## APPENDIX 1 - CONSULTATION LOG AND ABORIGINAL PARTY COMMENTS

**RE: NUNDAH BANK THIRD TRACK CULTURAL HERITAGE  
ASSESSMENT**

Thank you for the report dated October 2010. As noted, Sarah Hall (Cultural Heritage Fieldworker) of Wanaruah LALC participated in the surveys undertaken for this project. I have reviewed the report and comment as follows. I am sure you have been made aware of the 'cultural' sensitivity of the study area and therefore the Wanaruah LALC support the recommendations put forward by the traditional stakeholders in the protection and conservation of the sites.

Acknowledgements:
This product incorporates Data which is copyright to the Commonwealth of Australia (c.2003-)

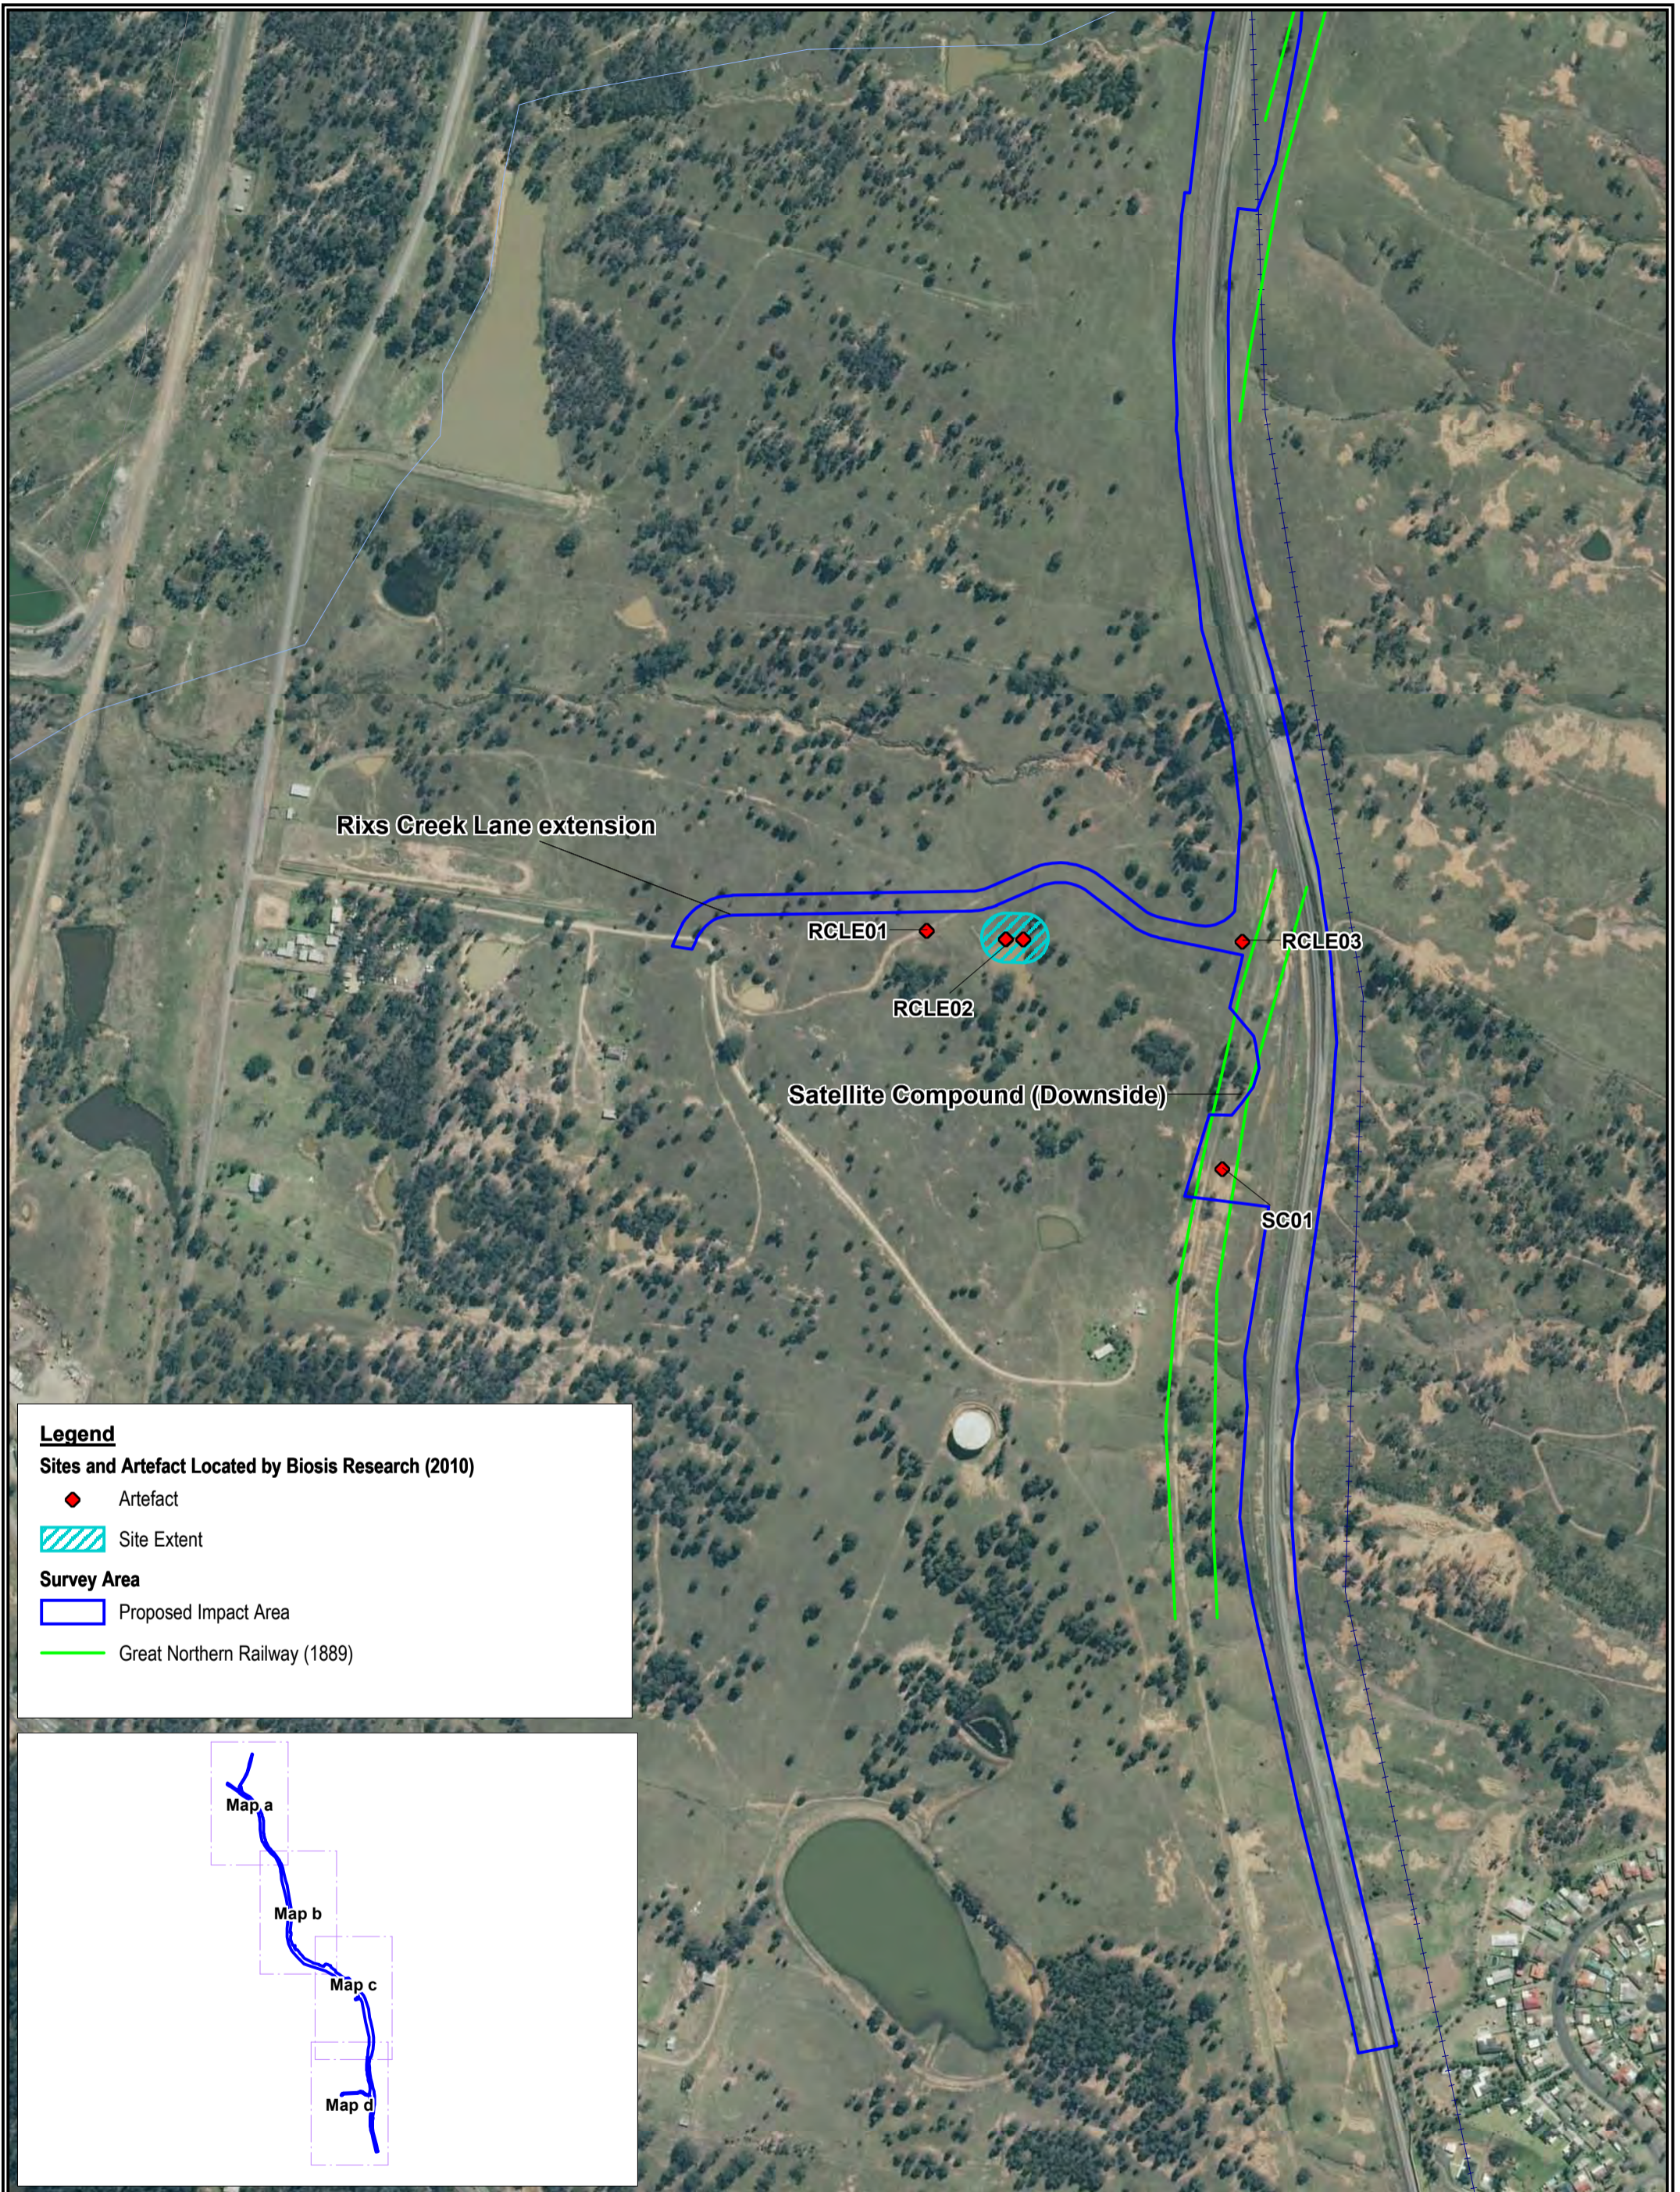
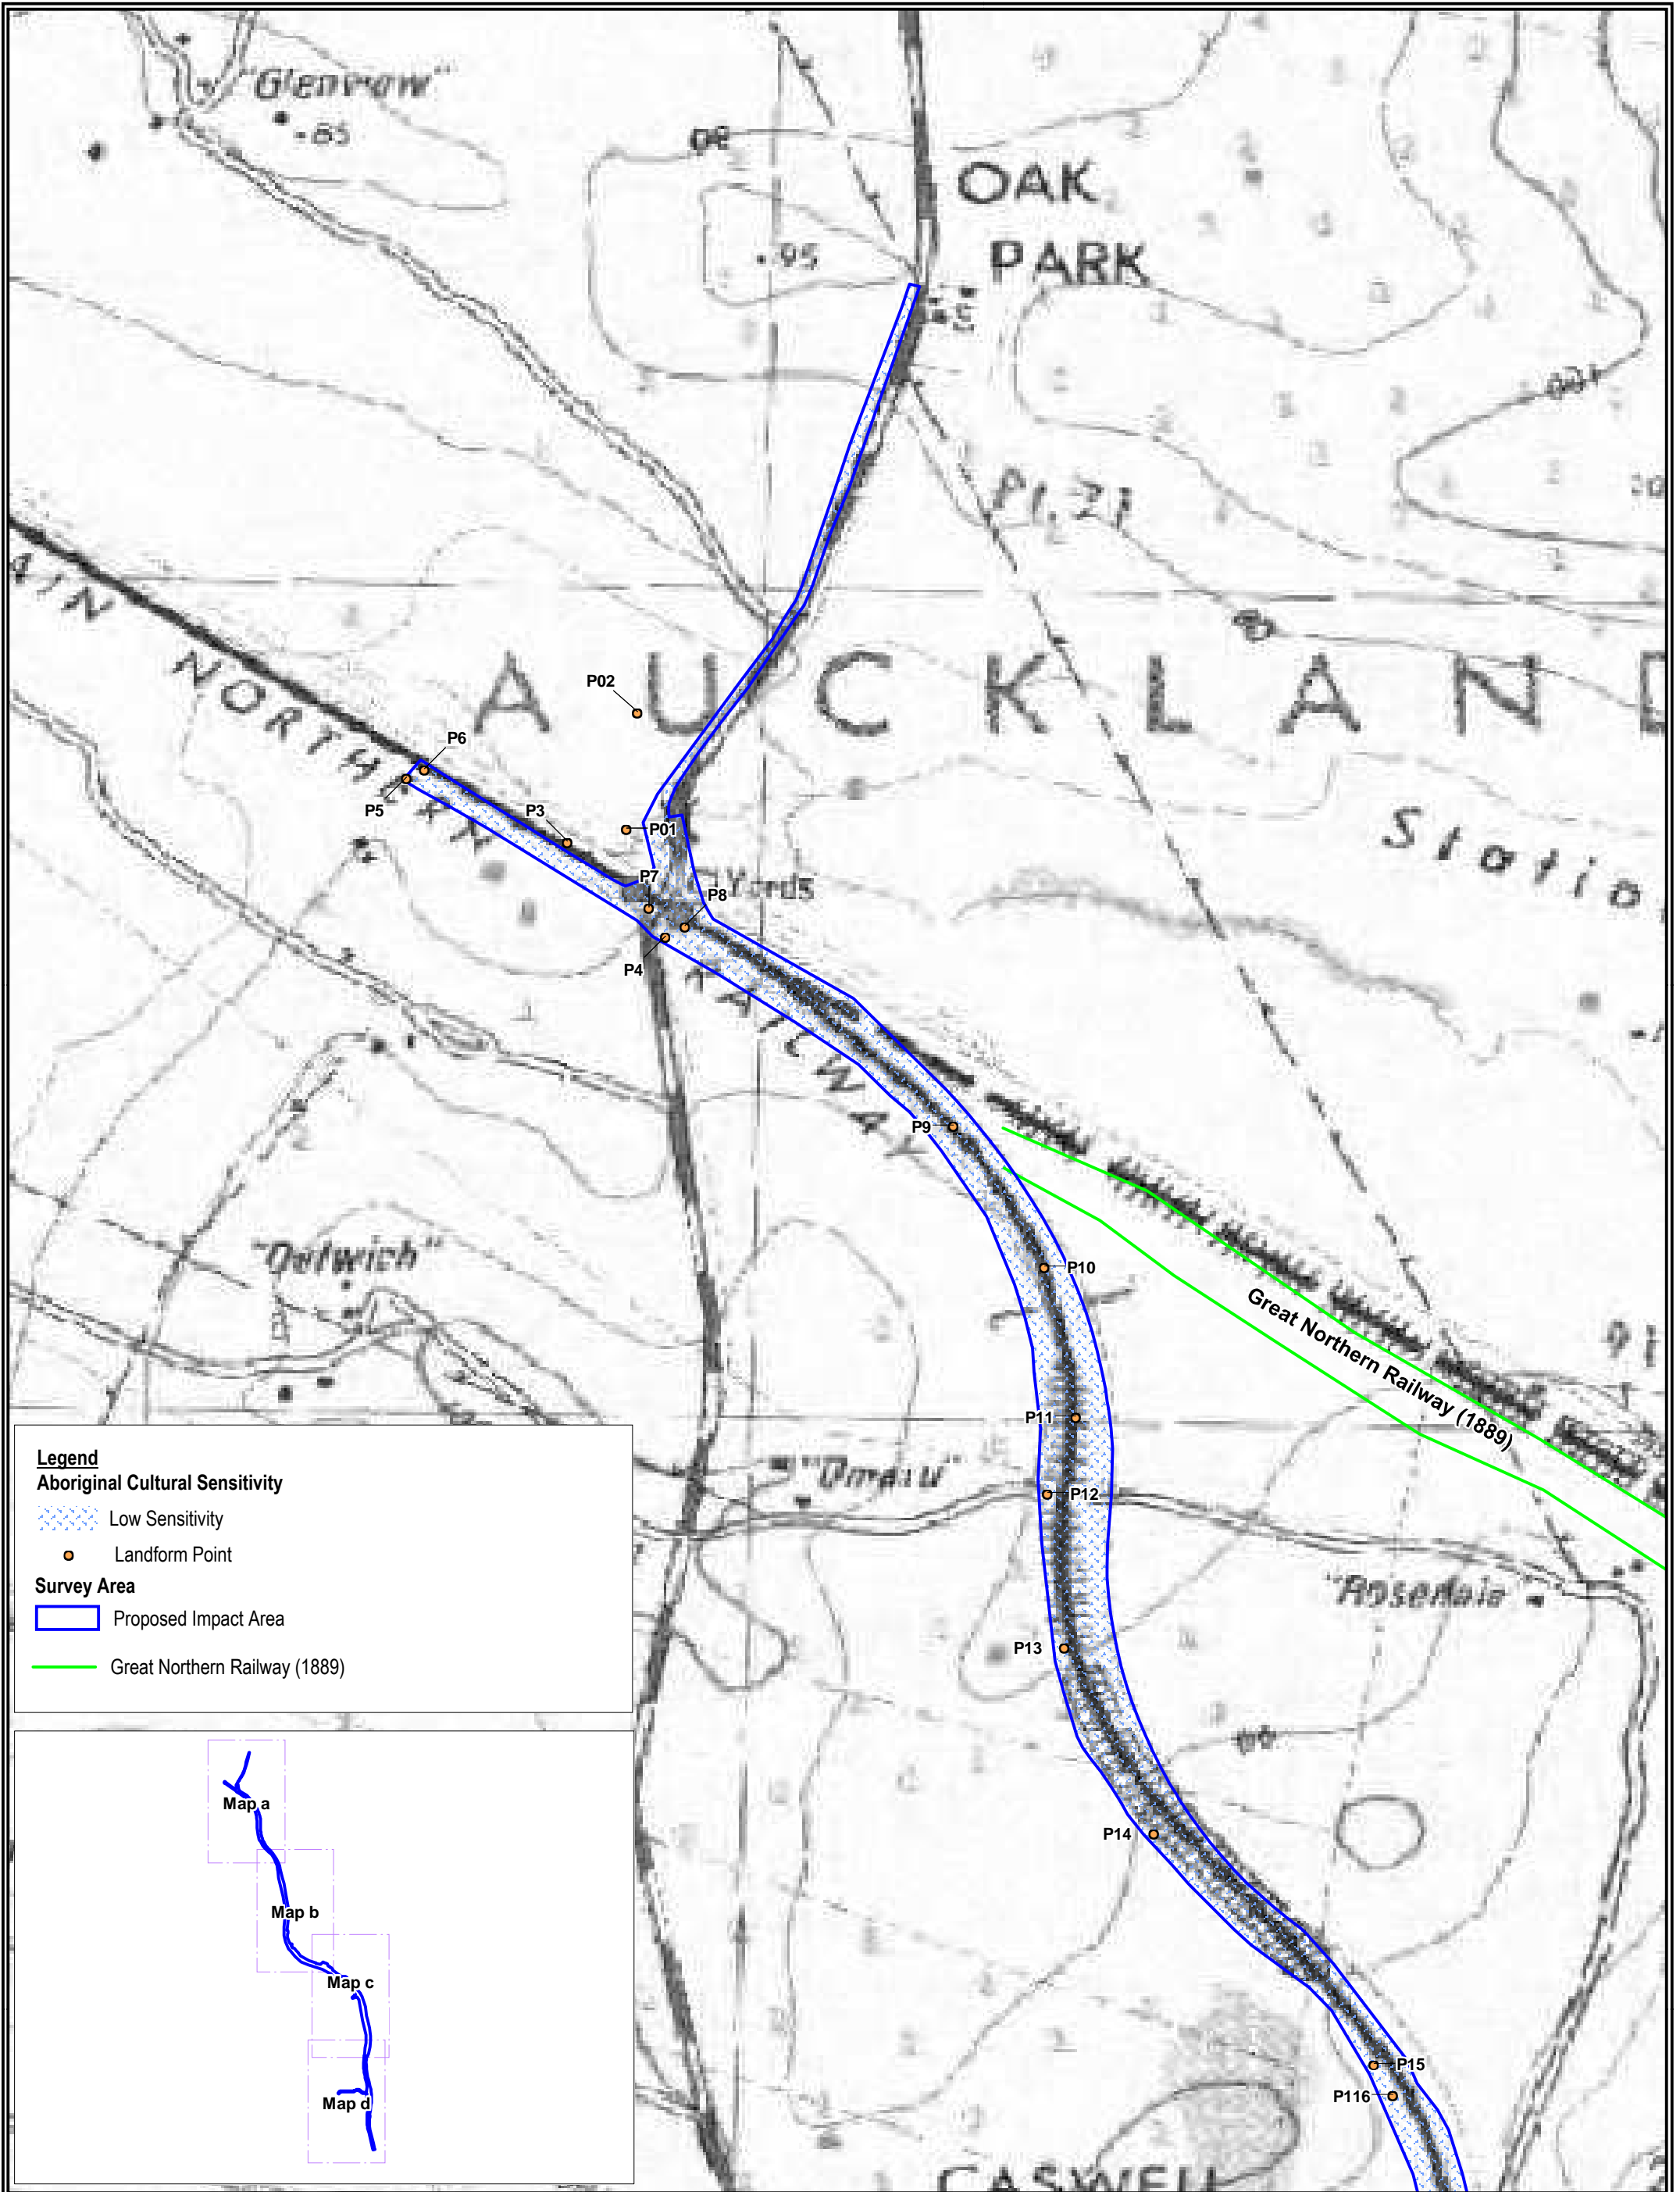
- That artefact salvage in accordance with a DECCW s90 AHIP is appropriate for all sites identified and recorded within the 'Project Area' marked on Figures 9a to 9e. This also includes those sites which are marked on the boarder of the 'Project Area' corridors. Railway construction is extremely detrimental to artefact sites and just placing fences around them will not protect the sites from heavy machinery etc.

- Those sites identified with 'Site Extent' should be further tested and salvaged in accordance with a DECCW s90 AHIP if you believe that there is subsurface material, particularly if the extent of an artefact scatter is over a wide area.

- Those sites identified and recorded outside the 'Project Area' corridors are to be temporarily fenced with relevant signage so that they will be protected during the rail line construction and truck and vehicle movements etc. nearby (eg. >5m outside and beyond the corridor edge).
